# PORTLAND MAINE

July 12, 2010

## NOTICE OF VIOLATION

**CBL: 013 D0010011**  
**Located at 34 OXFORD ST.**

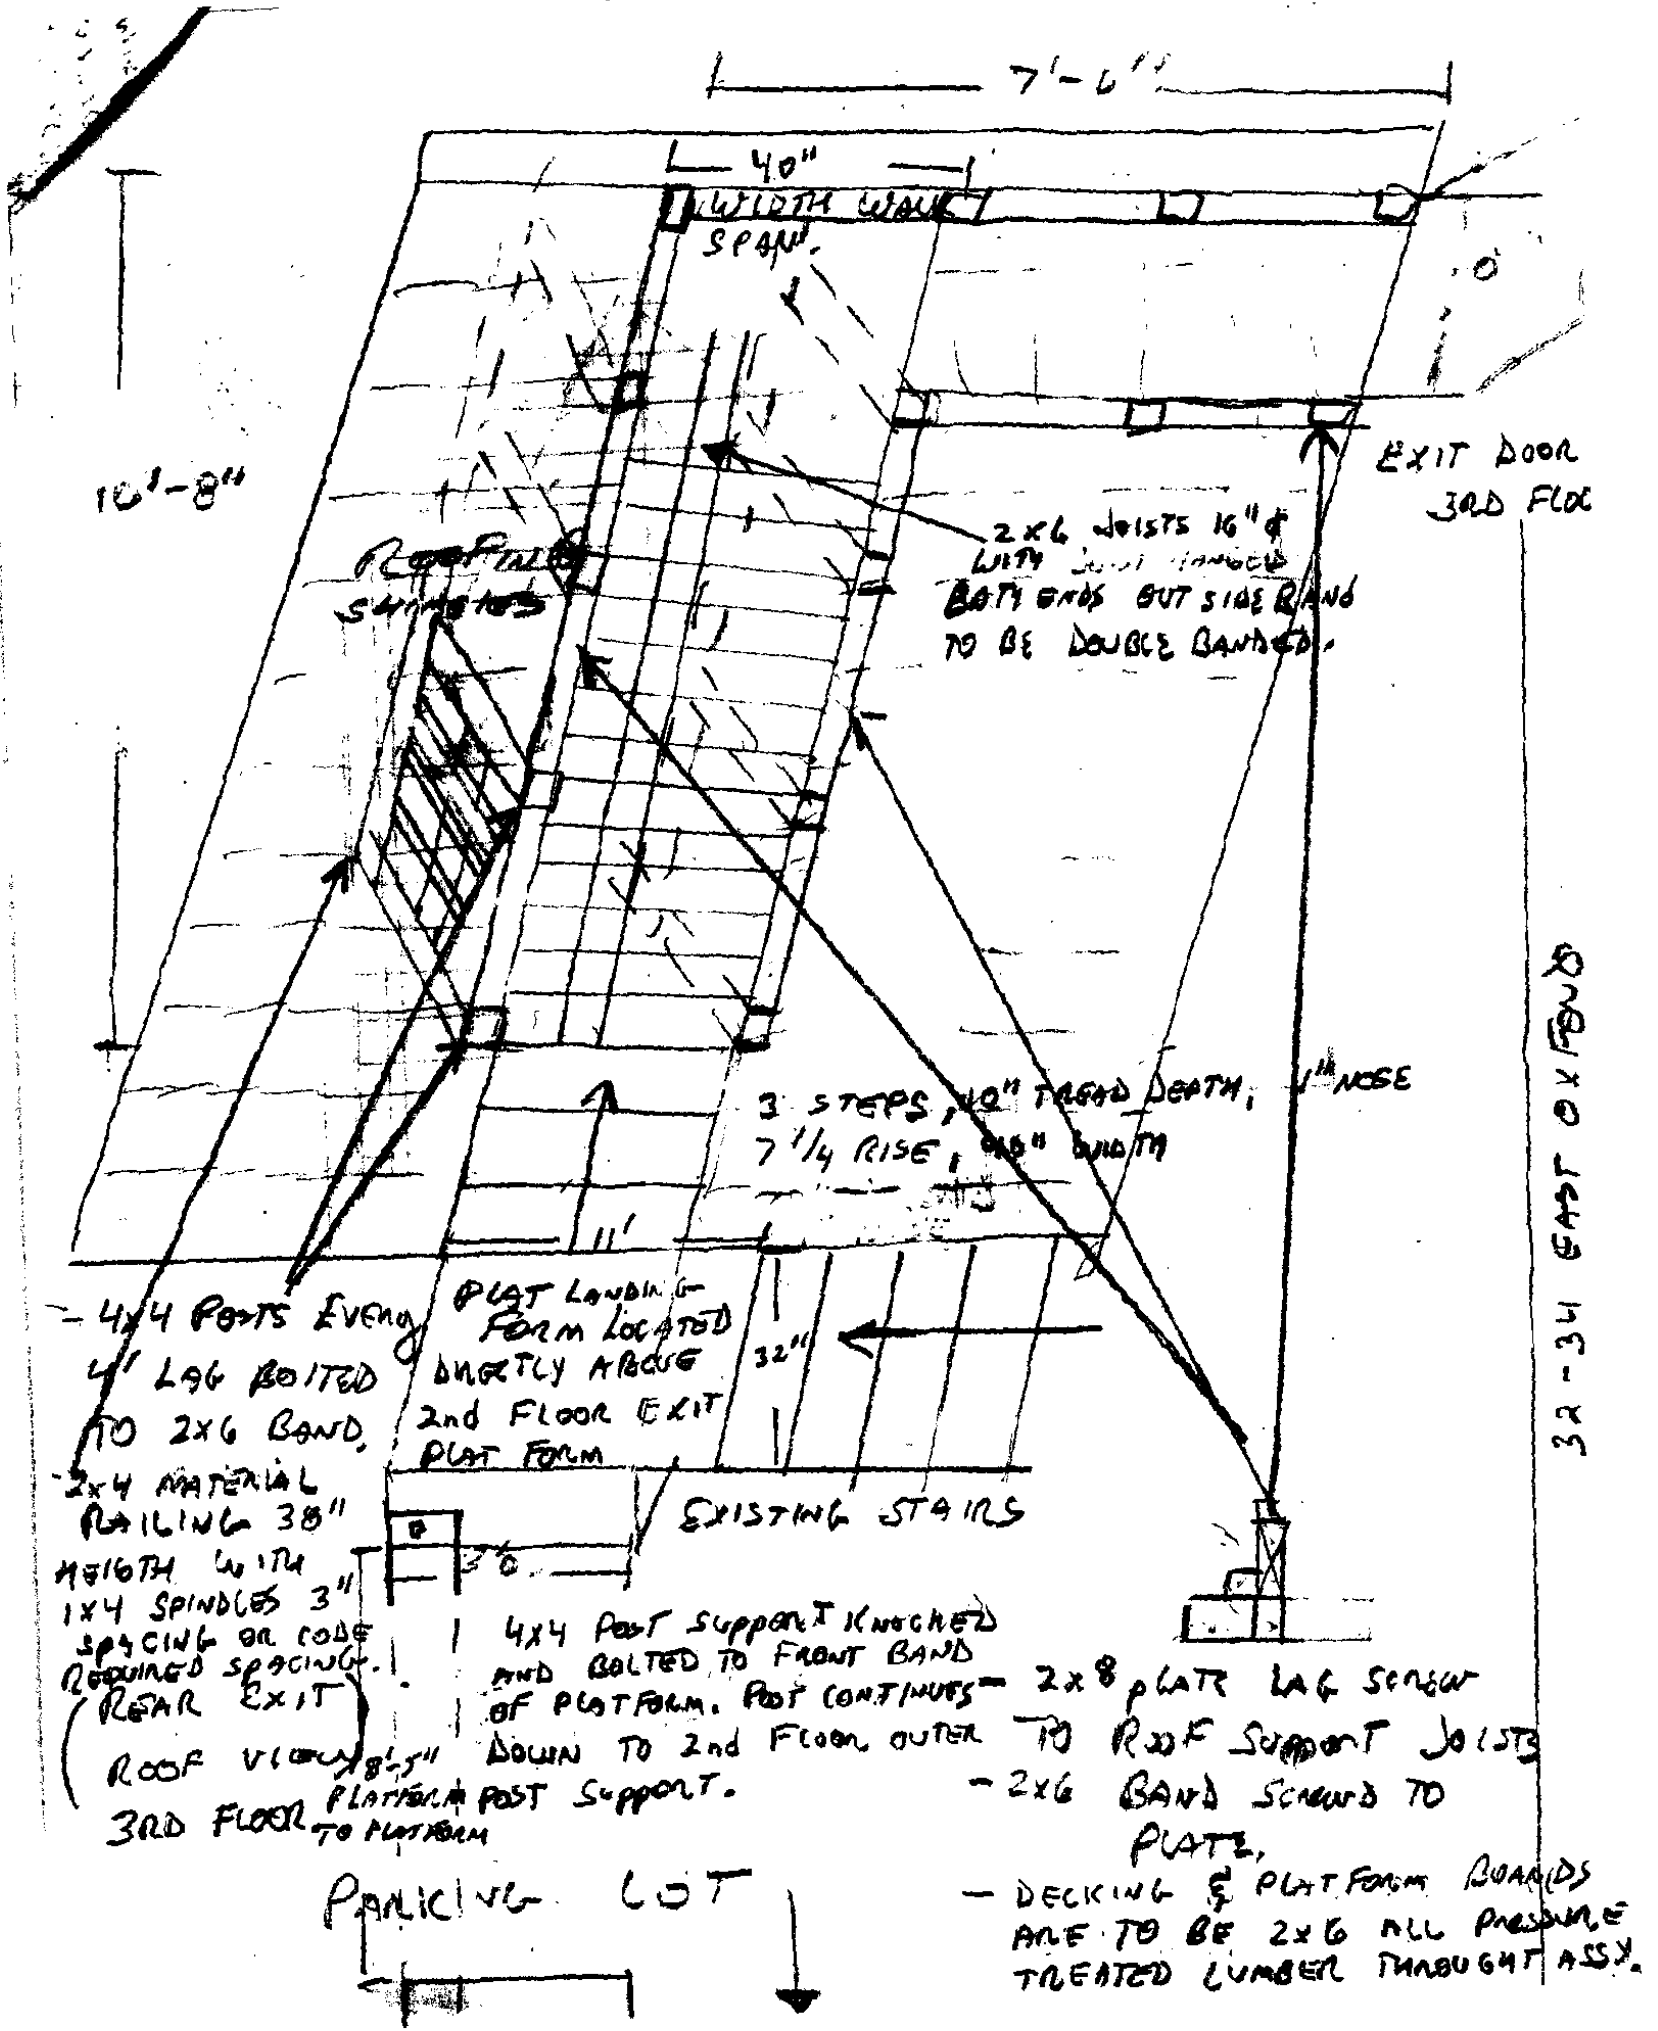
1. The 3<sup>rd</sup> floor exterior egress stair support, roof support beam/wall, construction of steps and platform to 3<sup>rd</sup> floor rooftop exit door, install temporary exterior door for first floor unit and maintain the wall weather tight at the end of work each day. Violations are to be corrected within 7 days of the date of this letter. A re-inspection of the premises is scheduled for Monday July 19, 2010 at 1:00 PM at which time compliance will be required. If compliance is not achieved at this time, Unit 3 is subject to being posted against occupancy. Please contact me prior to this date if you wish to change the time of this inspection.

2. The installation of the structural corner post and associated exterior wall framing, including all structural detail supporting the stairs, i.e. Canopy roof, posts to 4' frost piers.

1ST FLOOR UNIT - #1

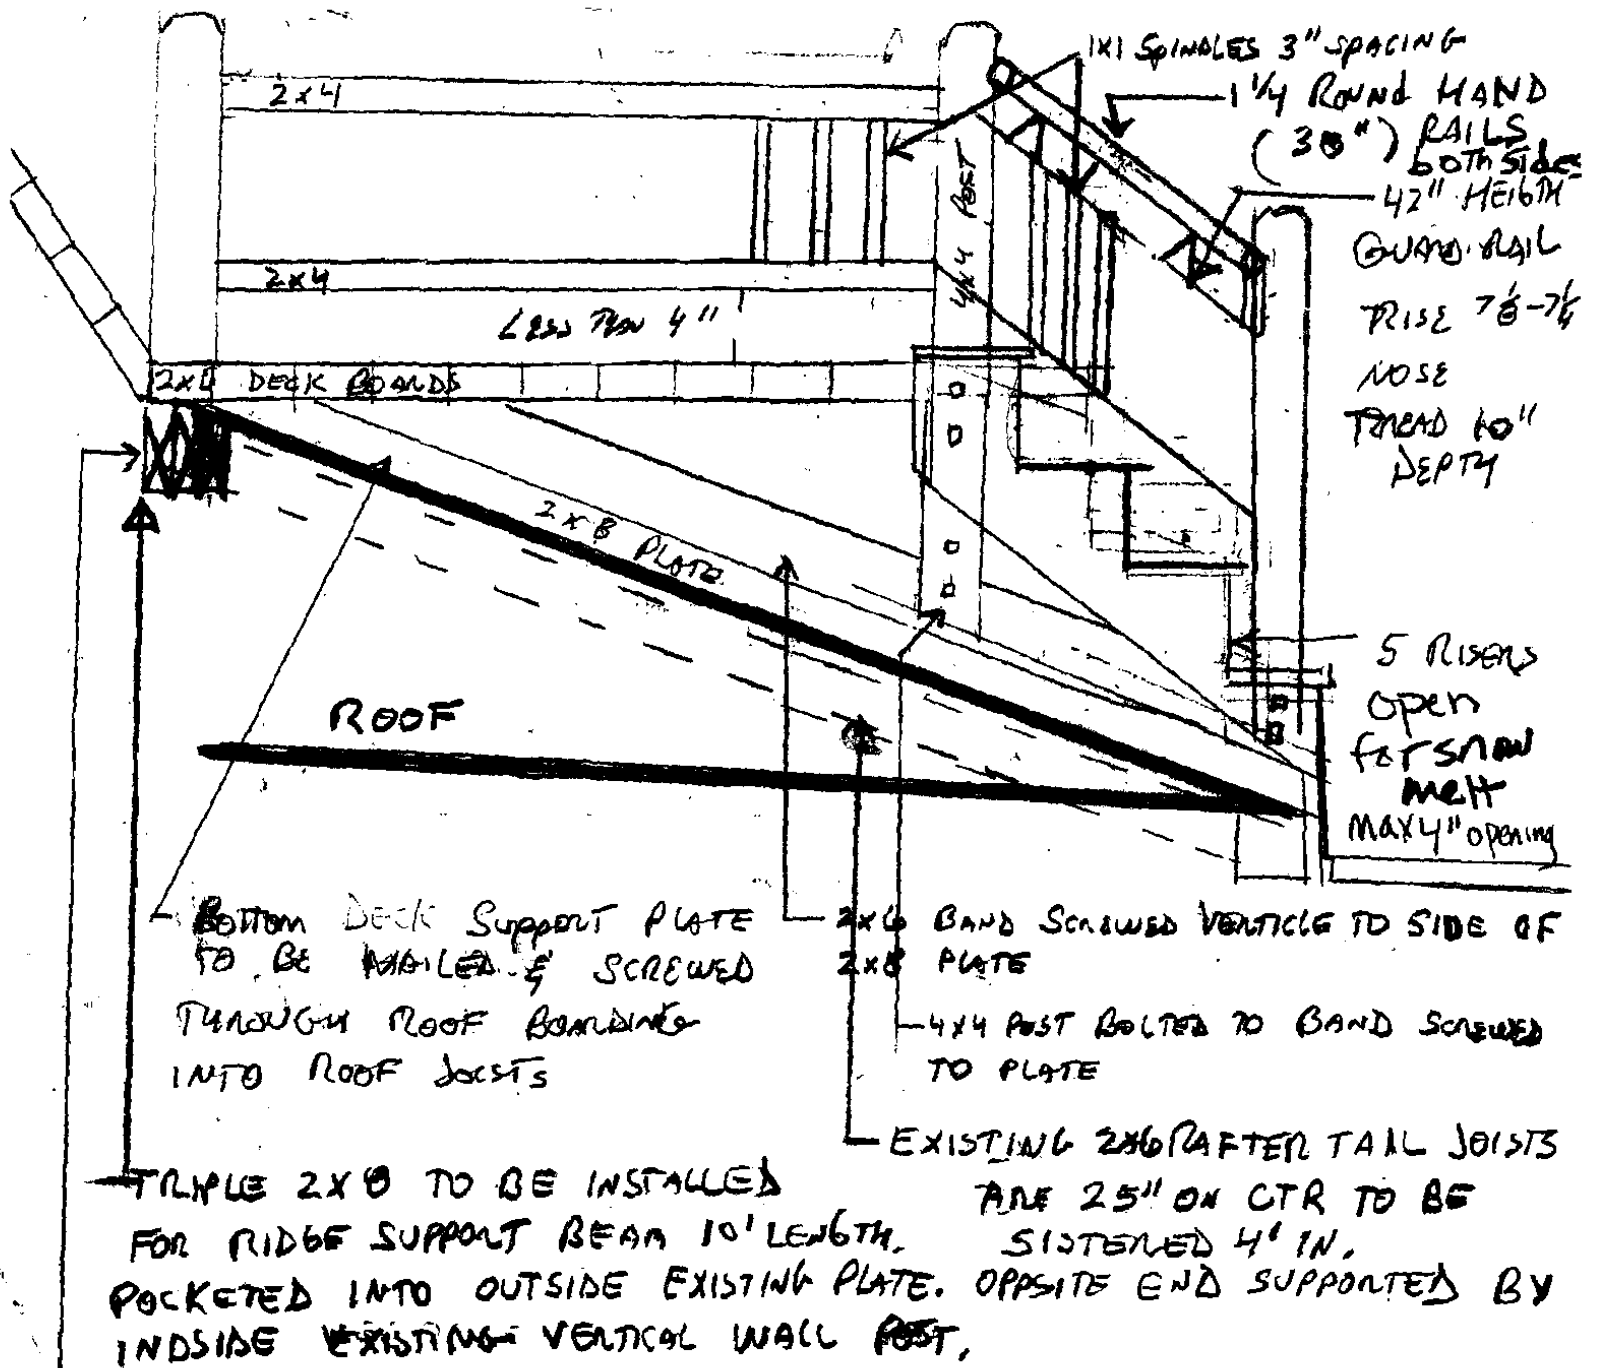
3. Complete the interior renovation of the 1<sup>st</sup> floor unit including electrical and life safety requirements. A licensed electrician shall obtain a permit and certify all installed work. Complete installation of all previously temporary electrical wiring to fixtures and receptacles throughout the building. Violations listed under numbers 2 & 3 are to be corrected within 30 days of the date of this letter. A re-inspection of the premises is scheduled for Wednesday August 11, 2010 at 1:00 PM at which time compliance will be required. If compliance is not achieved at this time, Unit 3 is subject to being posted against occupancy. Please contact me prior to this date if you wish to change the time of this inspection.
